April 3, 2017

**Baxter Academy Interior Fit-up - Response to Permit Review
Comments**

185 Lancaster Street, Portland, Maine

2 DARK ROOM (222A)  
1/2" = 1'-0"

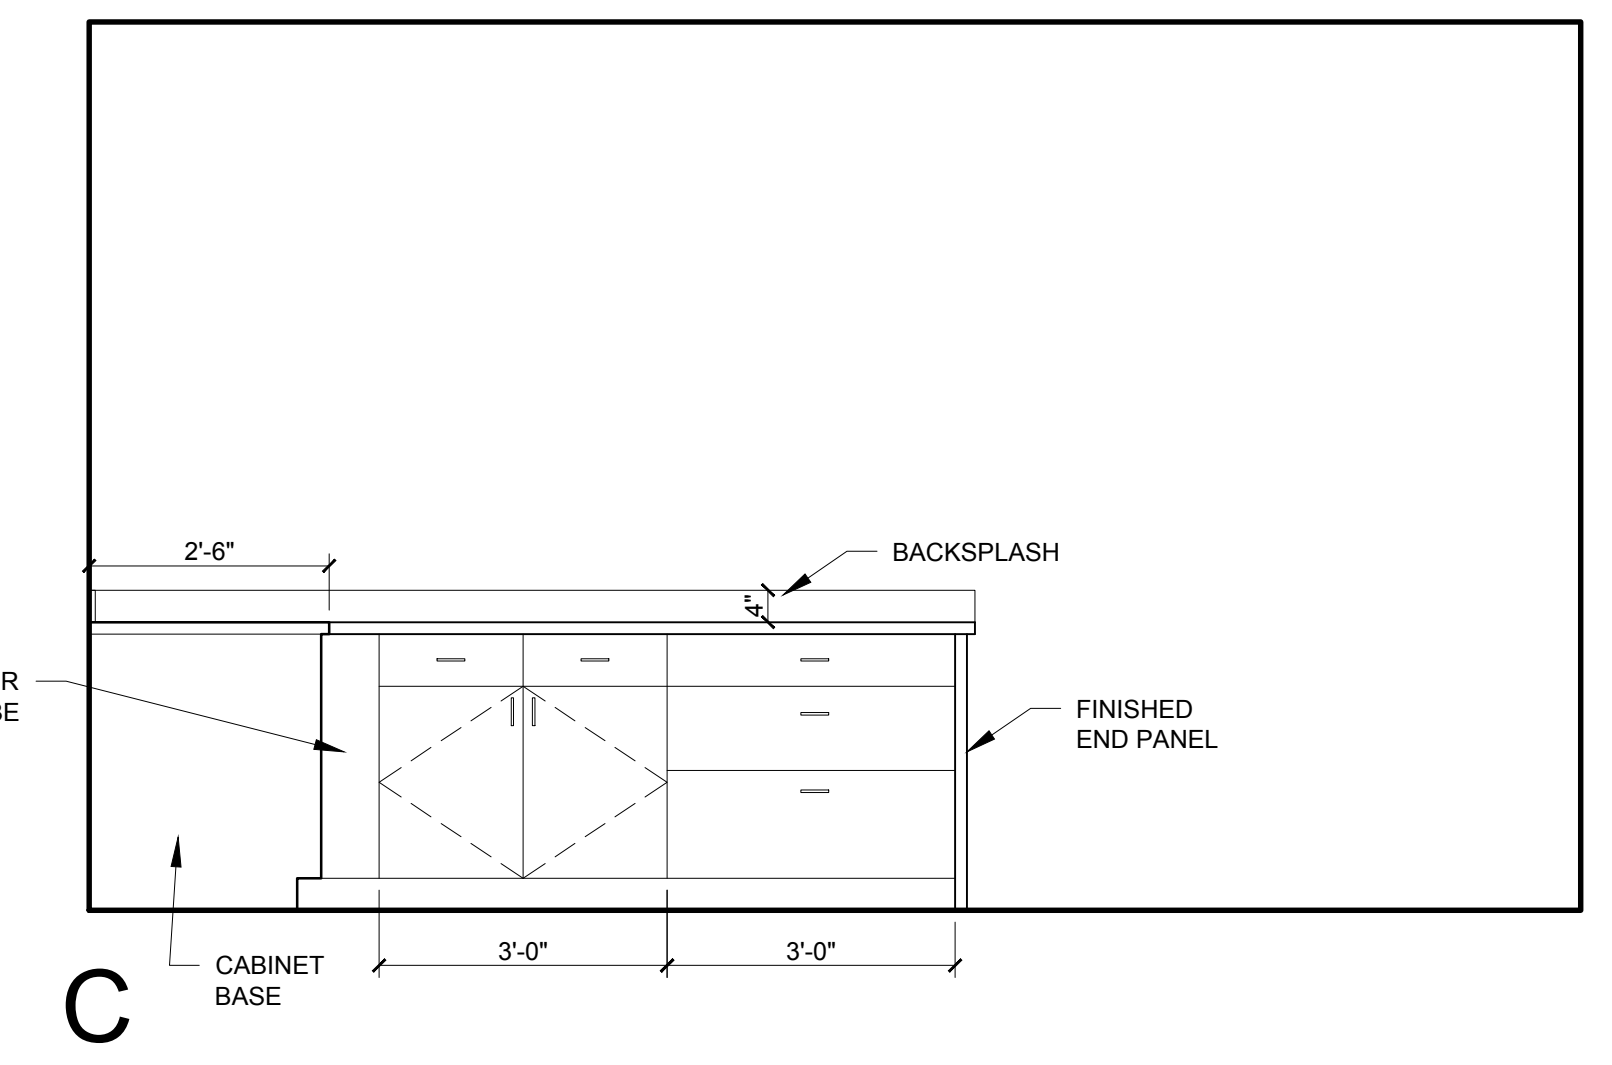
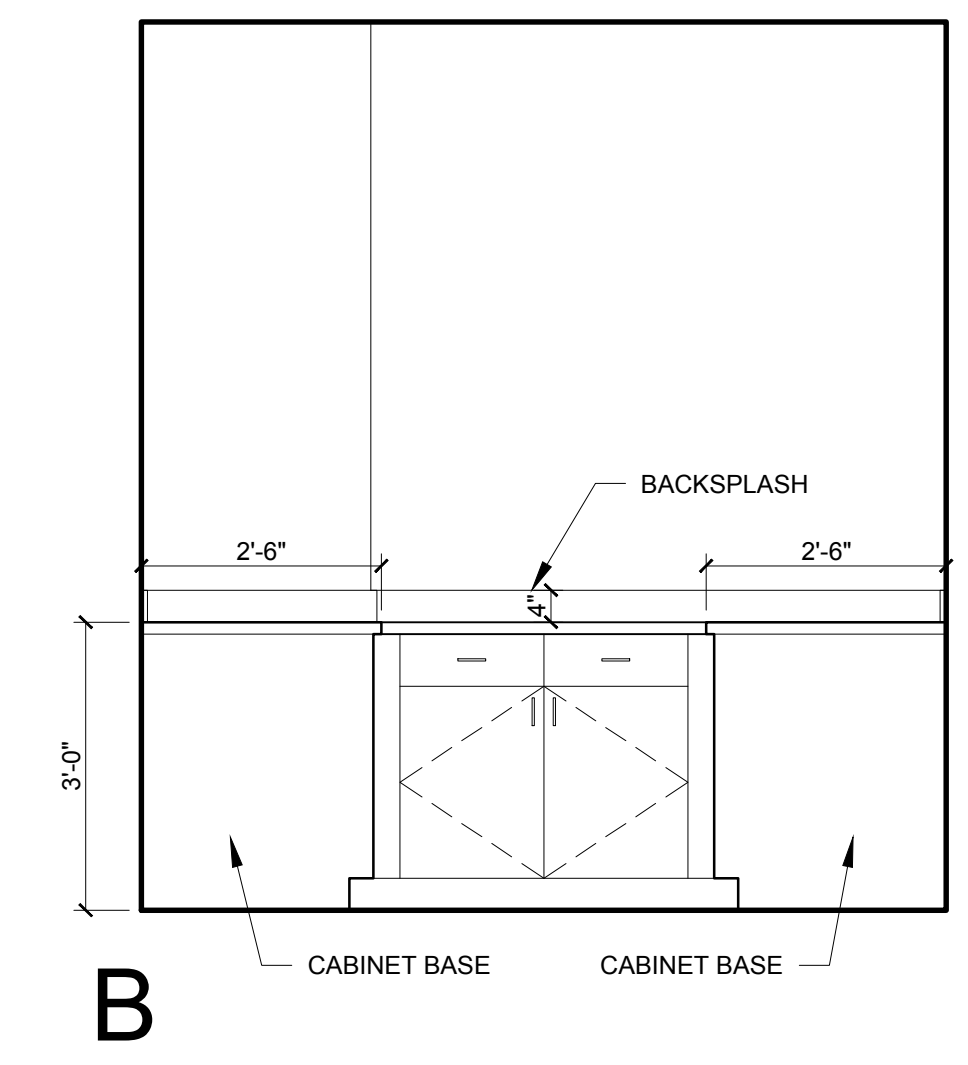
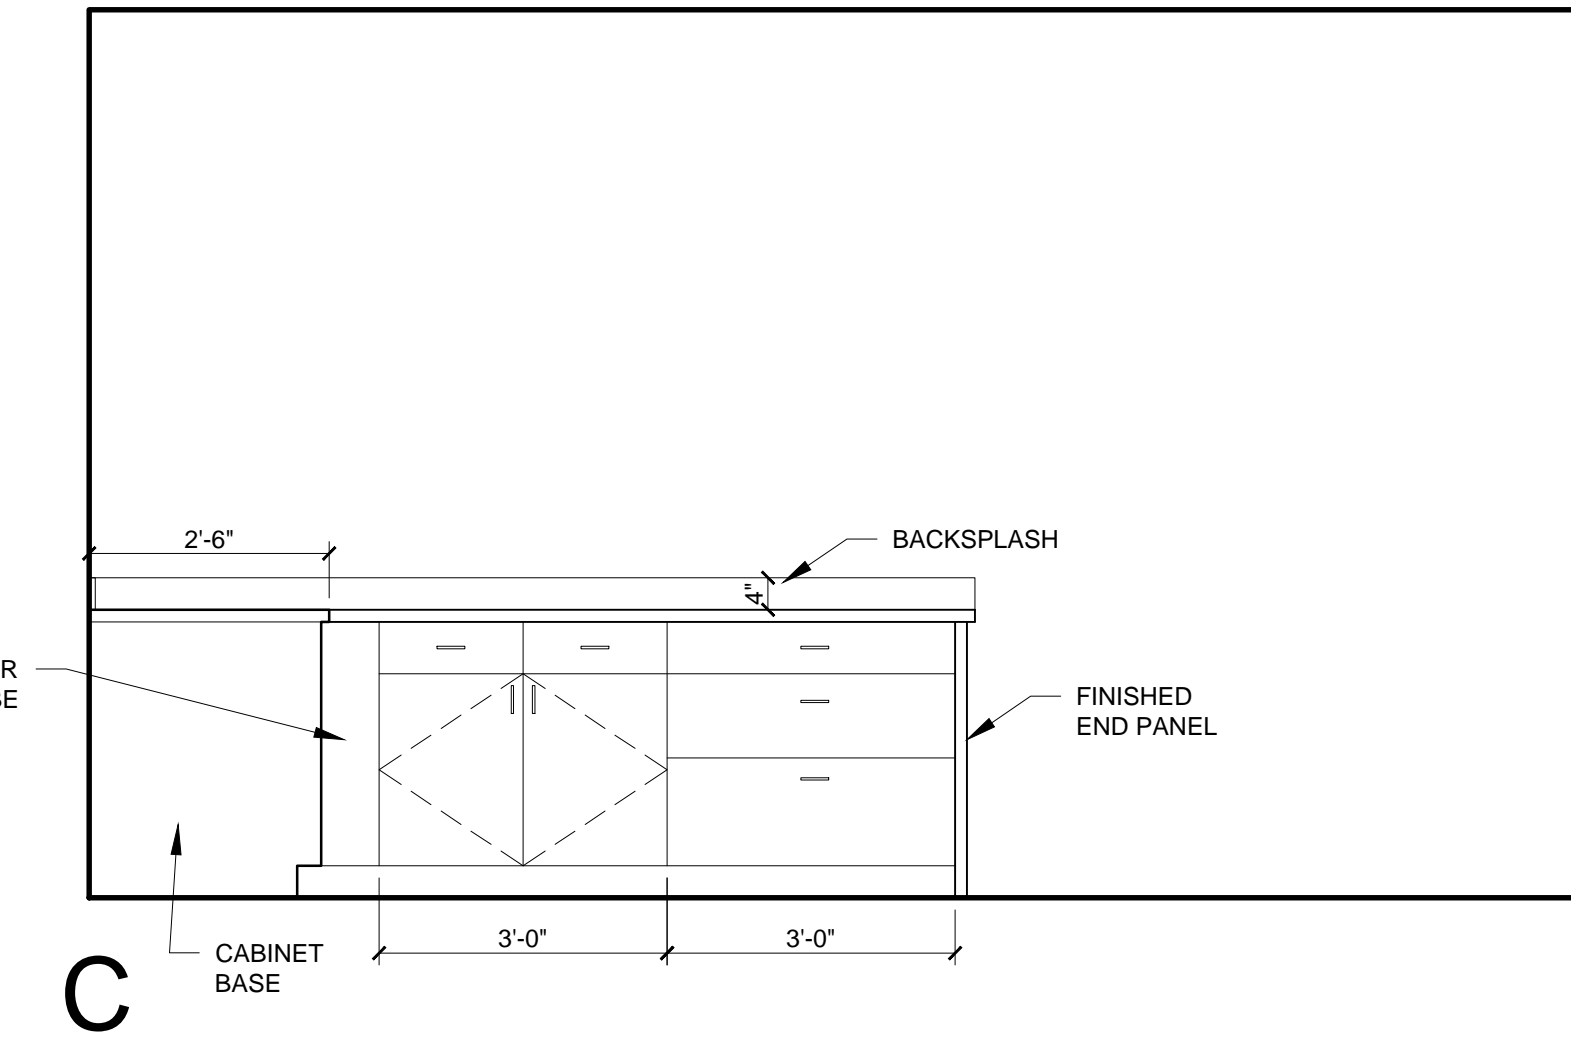
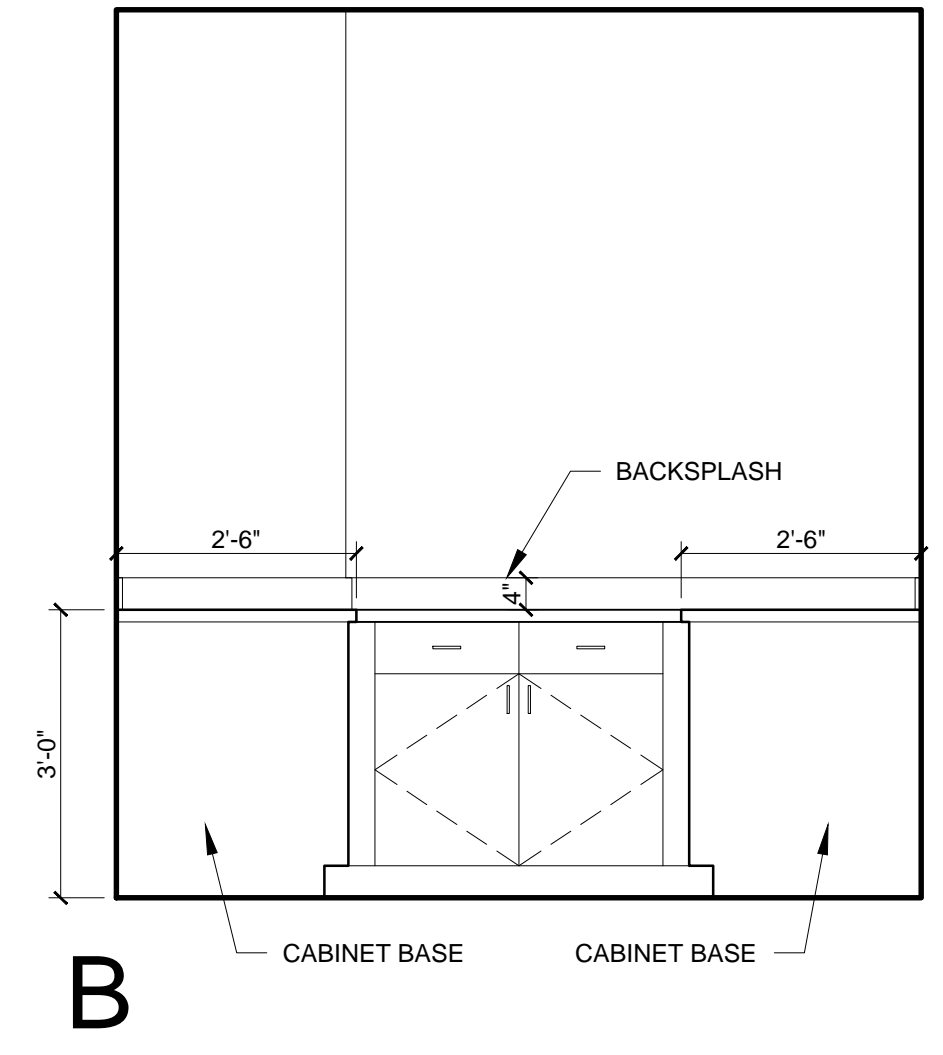
A4-5:

- We have provided an accessible sink in the Dark Room
